Ribble Valley Borough Council
Church Walk,
Clitheroe,
BB7 2RA

Phone: 0300 123 6780
Email: lhscustomerservice@lancashire.gov.uk
Your ref:
Our ref: LHS/CS/3/2016/0659
Date: 8th August 2016

Proposal:	Amendment of approved proposed access gates and gateposts to include new capping detail and stone flanking walls
Location:	The Eaves Pendleton Road Wiswell BB7 9BZ
Grid Ref:	375152 - 438114

Job No DWG No Rev
137/01 (02)007 #

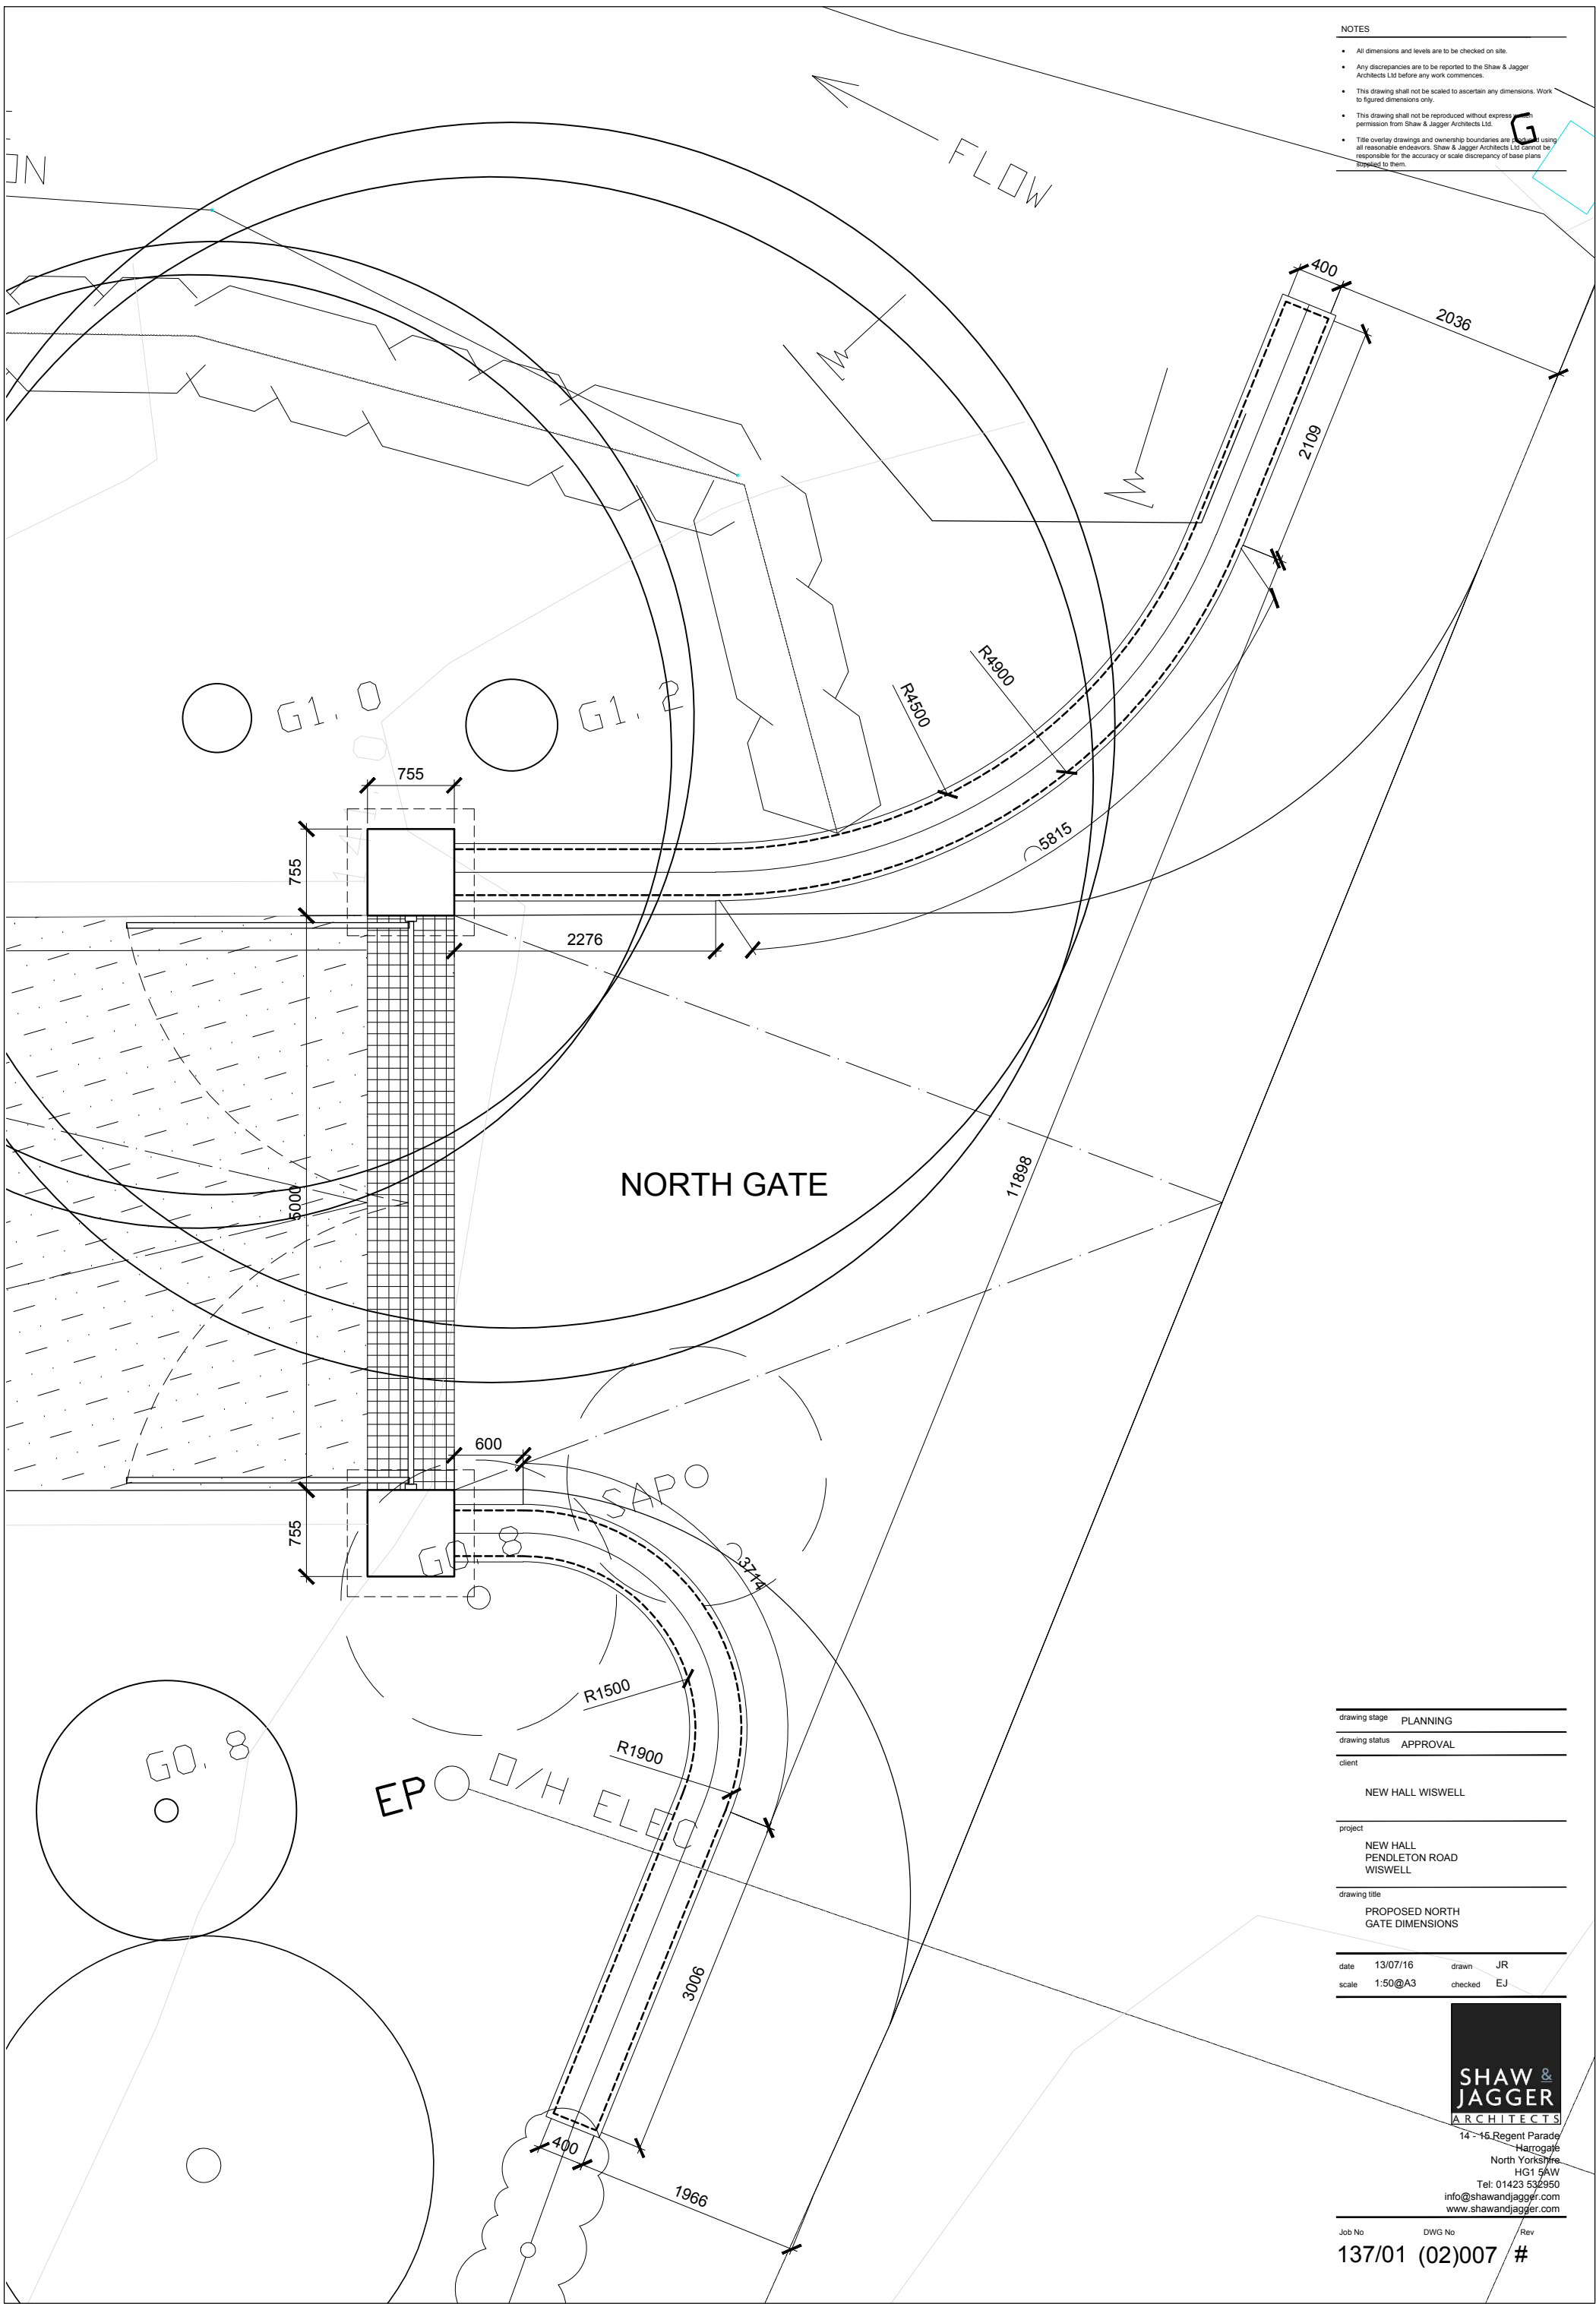
The Highway Development Control Section is of the opinion that the shown sight lines are incorrect as they should be to the near side kerb line and not the centre of the road.

The maximum height of any hedge wall etc within the sight line to be a maximum of 1.0m high.
